1. **Project # PR-2020-003707**
SI-2020-00247 – SITE PLAN

RESPEC agent(s) for SONATA TRAILS, LLC request(s) the aforementioned action(s) for all or a portion of: **TRACTS 1, 2 & 3, UNIT 4**, zoned MX-M, located at **UNIVERSE BLVD NW between PASEO DEL NORTE BLVD and TREELINE AVE NW**, containing approximately 29.9 acre(s). (C-10)

PROPERTY OWNERS: SONATA TRAILS LLC
REQUEST: APARTMENT COMPLEX DEVELOPMENT

SHEET TITLE:  
**CONCEPTUAL OVERALL GRADING PLAN**

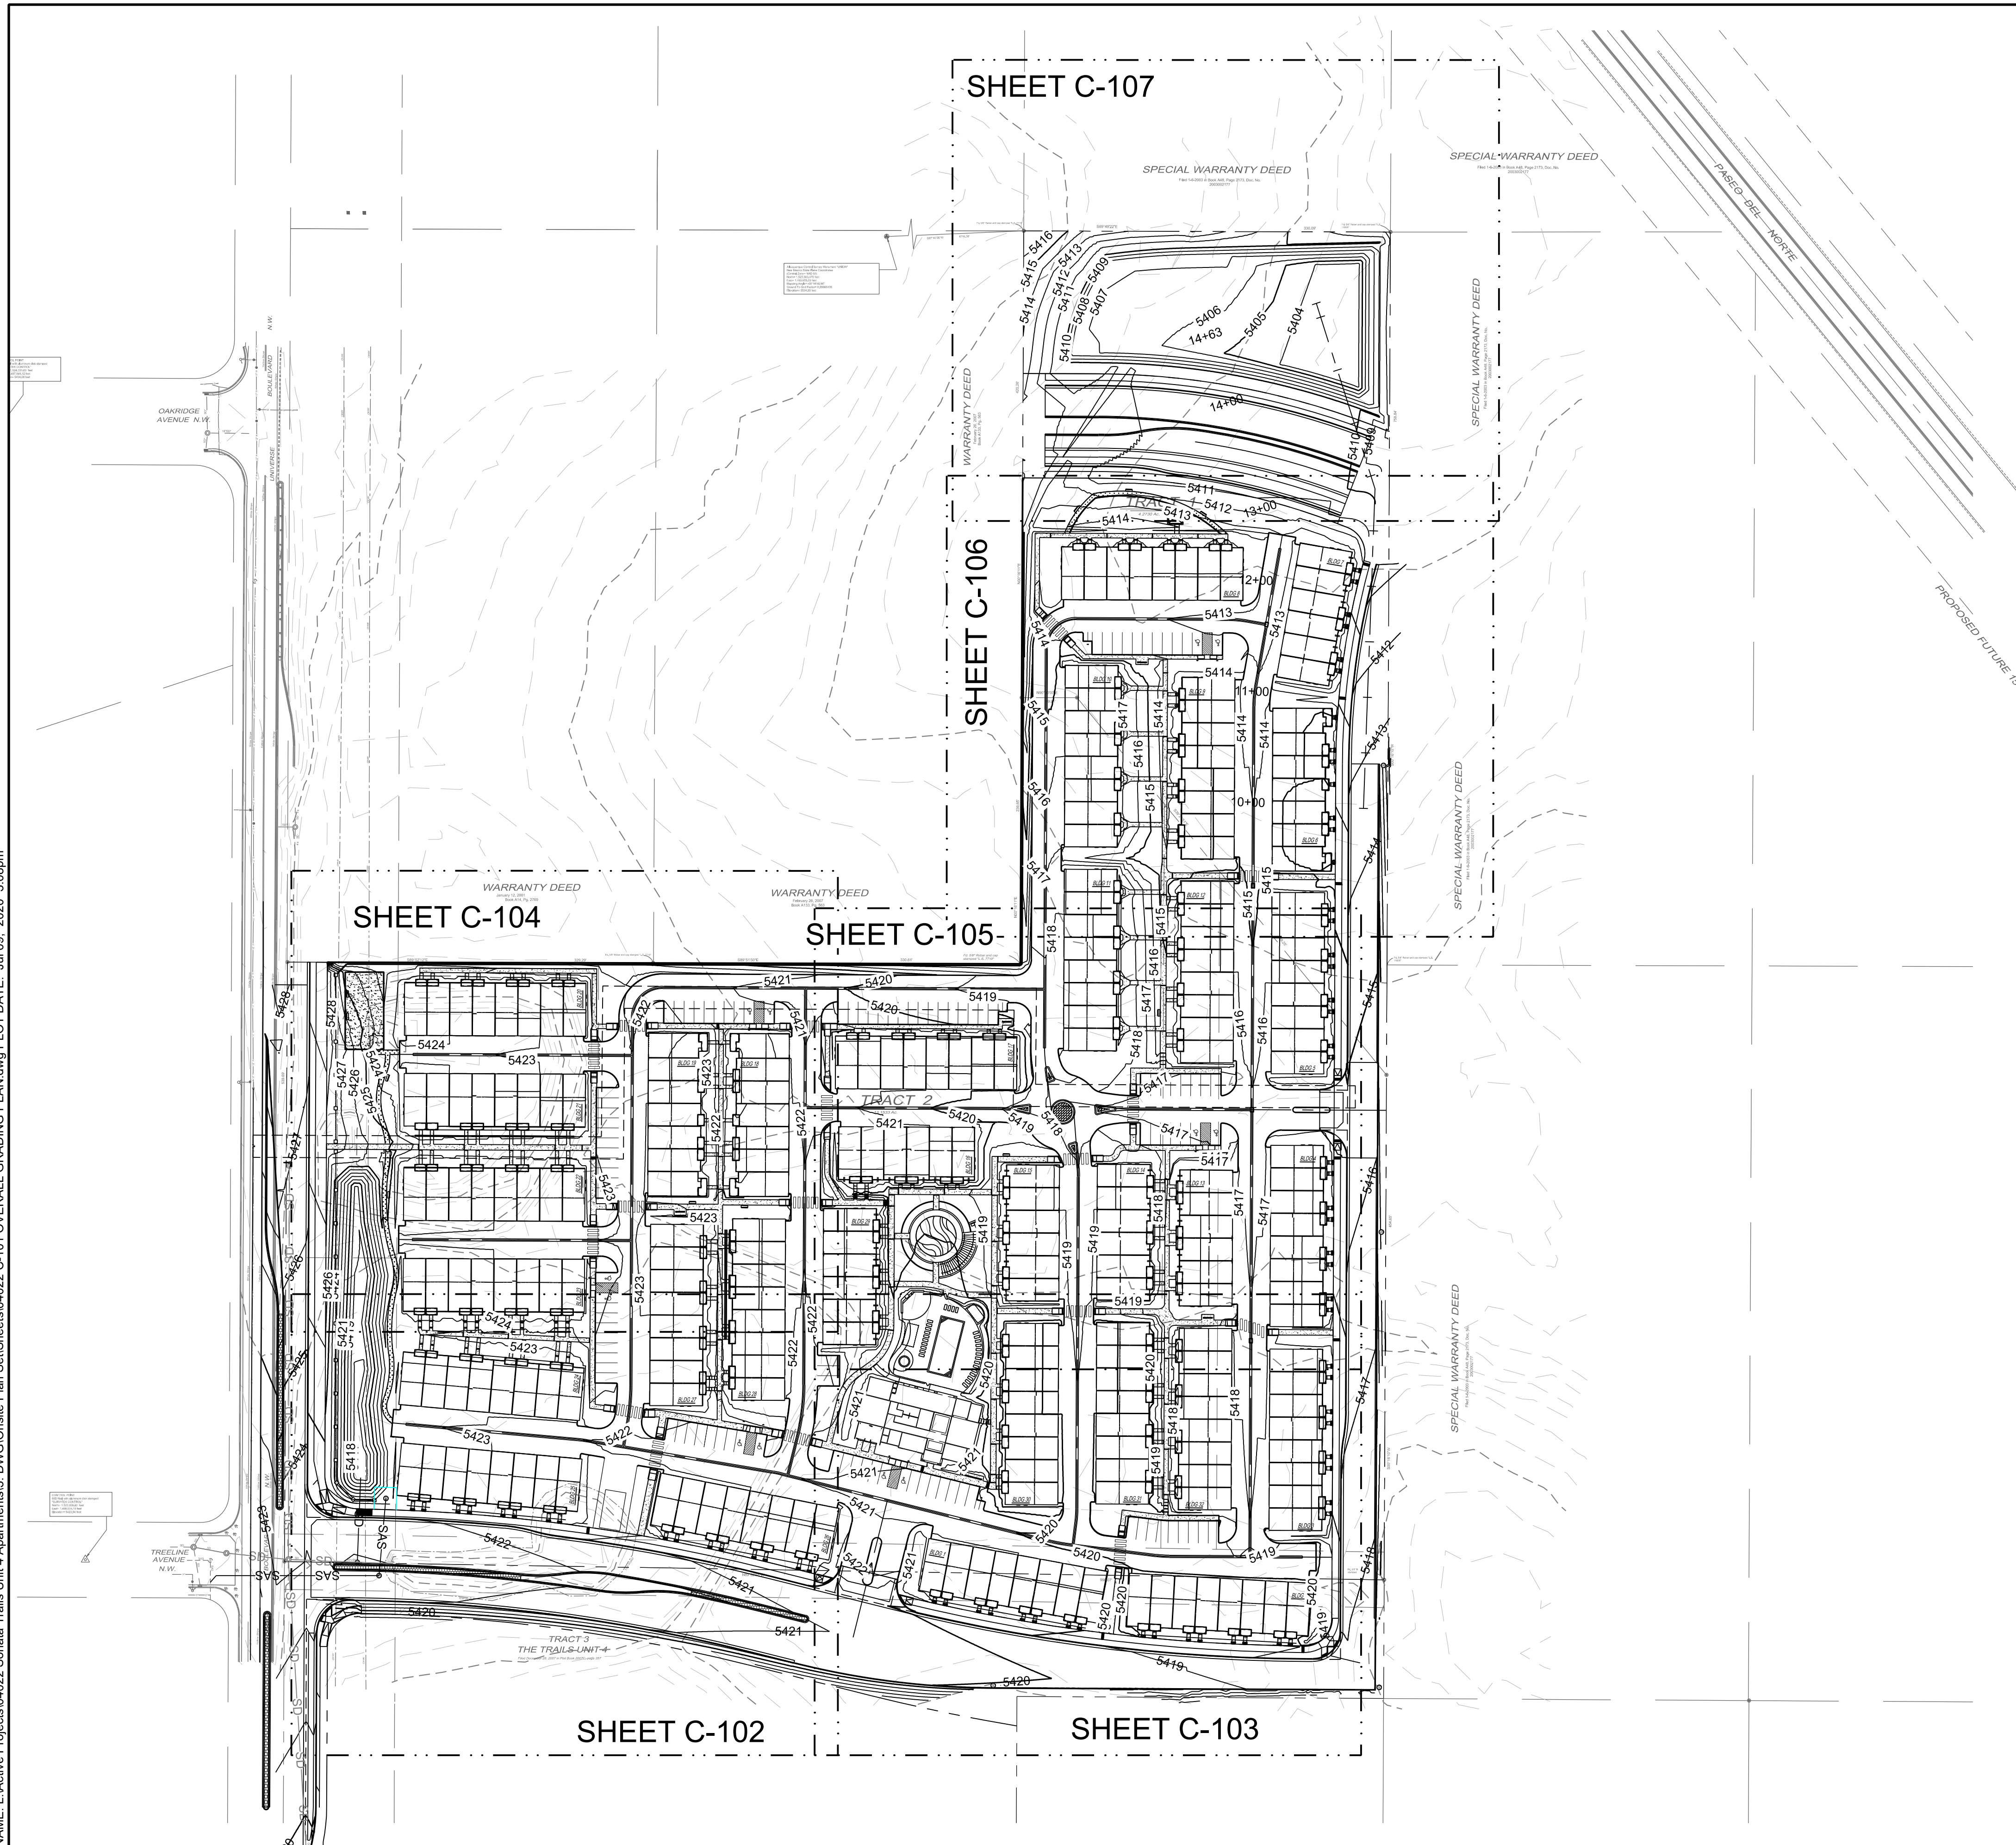
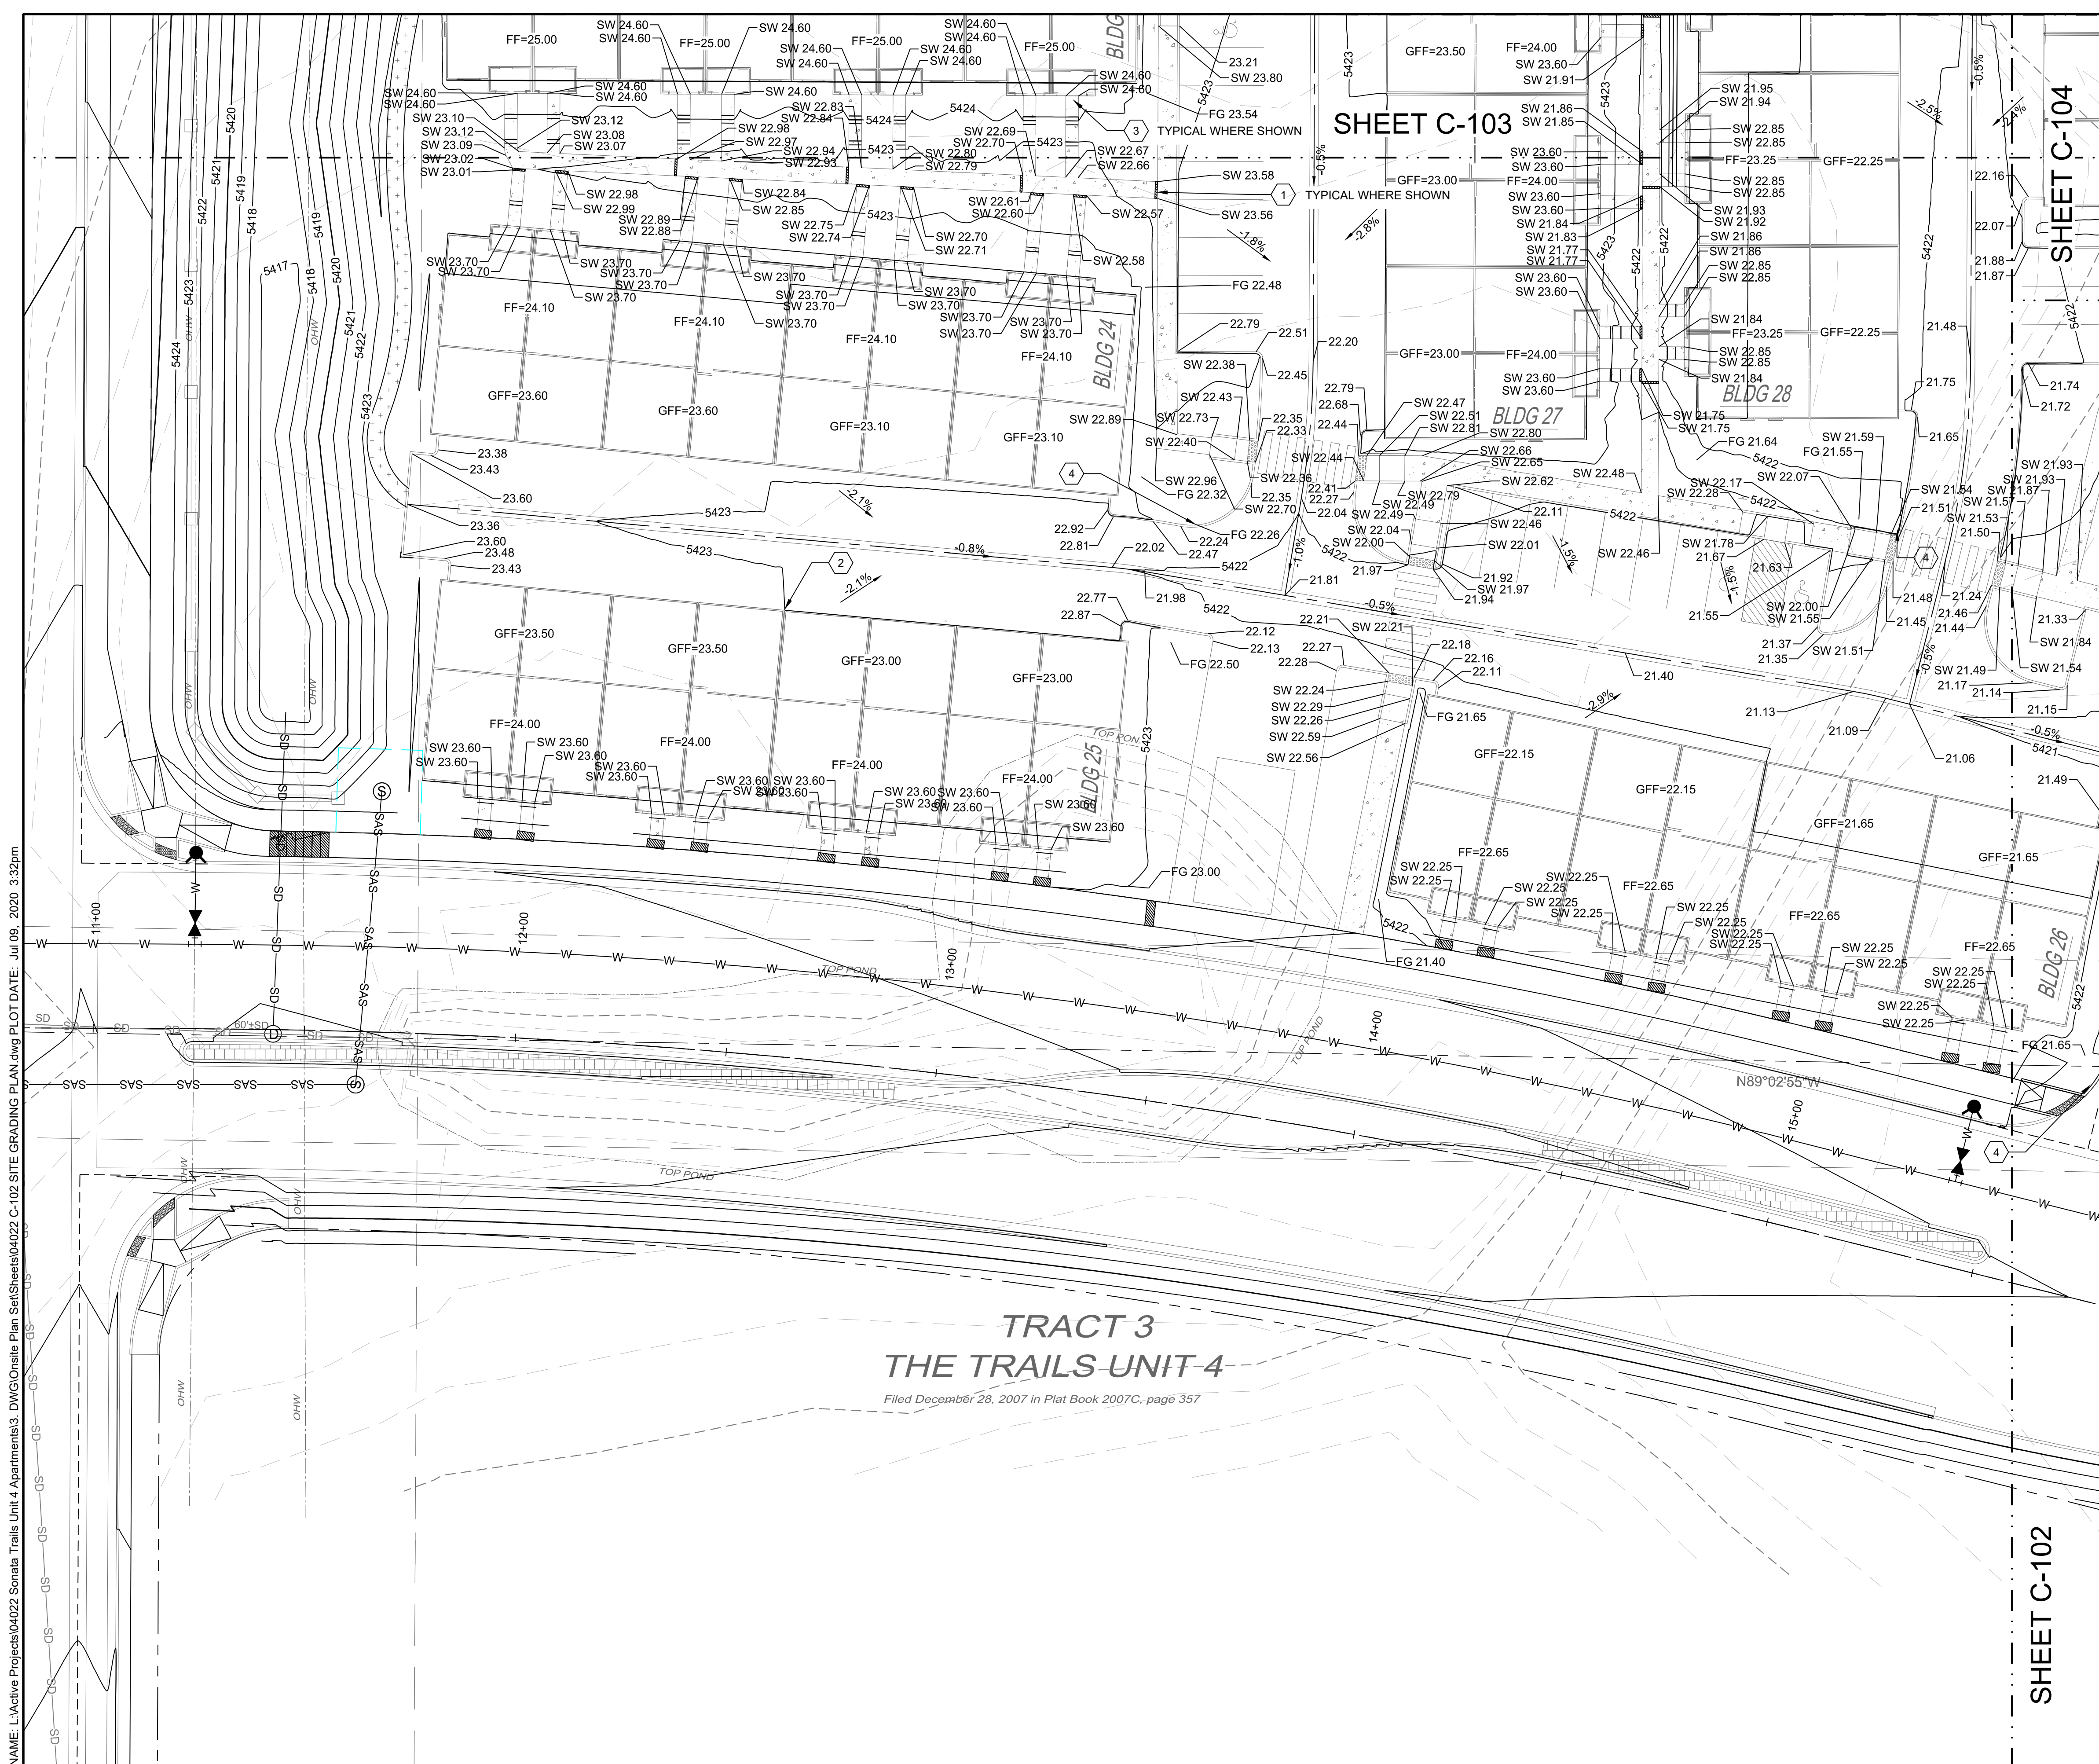
Drainage: There has been a Volcano Heights Infrastructure Plan in the works for over 3 years and that any development in Volcano Heights should align with that infrastructure plan. Also, the City should provide some backbone water / storm water / sanitary sewer infrastructure in the area to avoid the need for temporary facilities such as the “temporary” pond shown at the north end of the proposed development near PDN. Is it temporary? What would have to occur for it to be put into use in the future? These temporary facilities are costly and may not be the best location for the overall development of the area.

AMAFCA completed the Upper Piedras Marcadas Drainage and Water Quality Management Plan in April 2017. This plan took over 3 years to complete and identified general pond locations in the area. AMAFCA initiated the process to acquire land to construct the pond(s). Has this process been completed and how does the Sonata Trails LLC project impact the plan?
